Yorkshire Water Services
Developer Services
Sewerage Technical Team
PO BOX 52
Bradford
BD3 7AY

Your Ref: 2024/92081
Our Ref: A003731

land adj, 36, Oxford Road, Dewsbury, WF13 4LL - Discharge of details reserved by conditions 3 (Remediation Strategy), 5 (CEMP: Biodiversity), 6 (CEMP), 7 (Arboricultural Method Statement), 8 (highway condition survey), 9 (Drainage strategy), 10 (Temporary drainage), 11 (BEMP) and 15 (oil / petrol interceptor) of previous permission 2023/92712 for erection of 40 bed care home and 12 independent supported living units (use class C2) with associated works including the formation of car park and service access

1.) Yorkshire Water has no objection in principle to the drainage details submitted on drawing 'PROPOSED BELOW GROUND DRAINAGE LAYOUT' LE-161-CCS-01-00-DR-S-0200 (revision P03) dated 12/01/24 that has been prepared by CCS

Project Number | Originator | Vol. | Level | Type | Role | Number
LE-161 - CCS - 01 - 00 - DR - S - 0200 P03

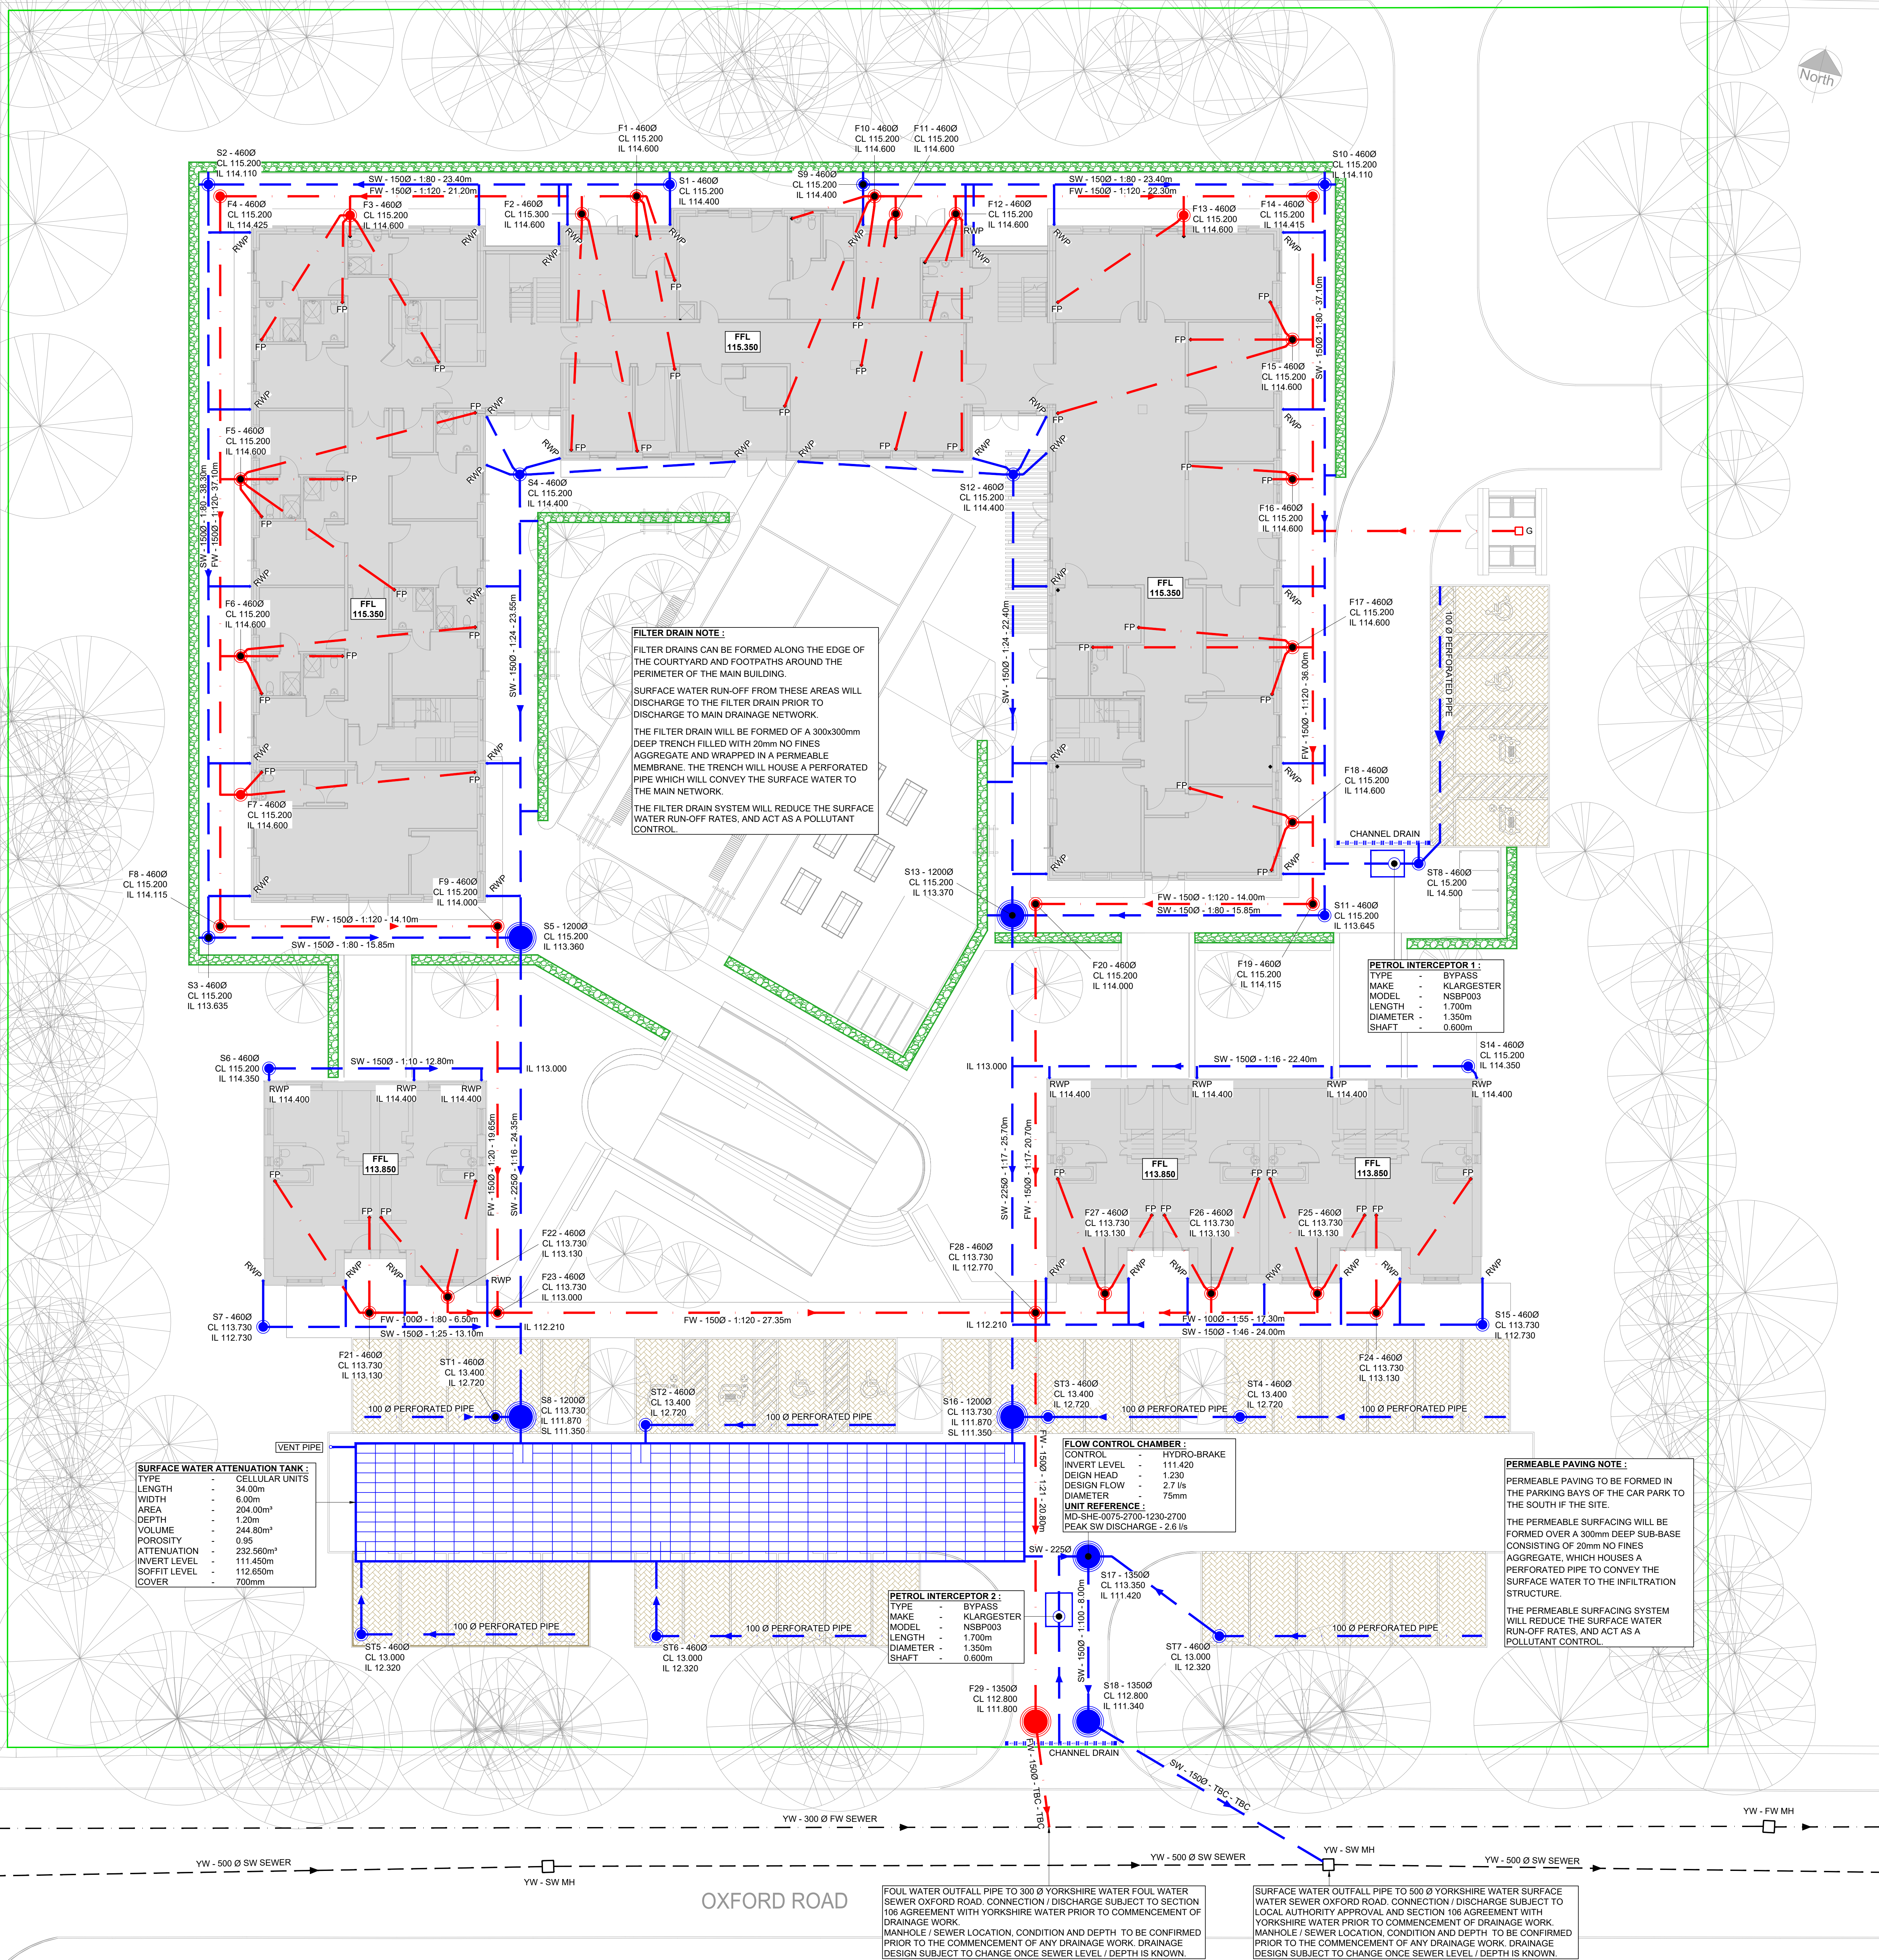
- a.) The proposed separate systems of drainage on site and off site
- b.) The proposed amount of domestic foul water to be discharged to the public combined water sewer

- c.) The proposed amount of curtilage surface water to be discharged to the public surface water sewer at a restricted rate of 2.7 litres/second
- d.) The proposed point(s) of discharge of foul and surface water to the respective public sewers
- e.) The proposed use of the petrol/oil/grit separator/interceptor

Yorkshire Water has no objection to the discharge of conditions 9 & 15.
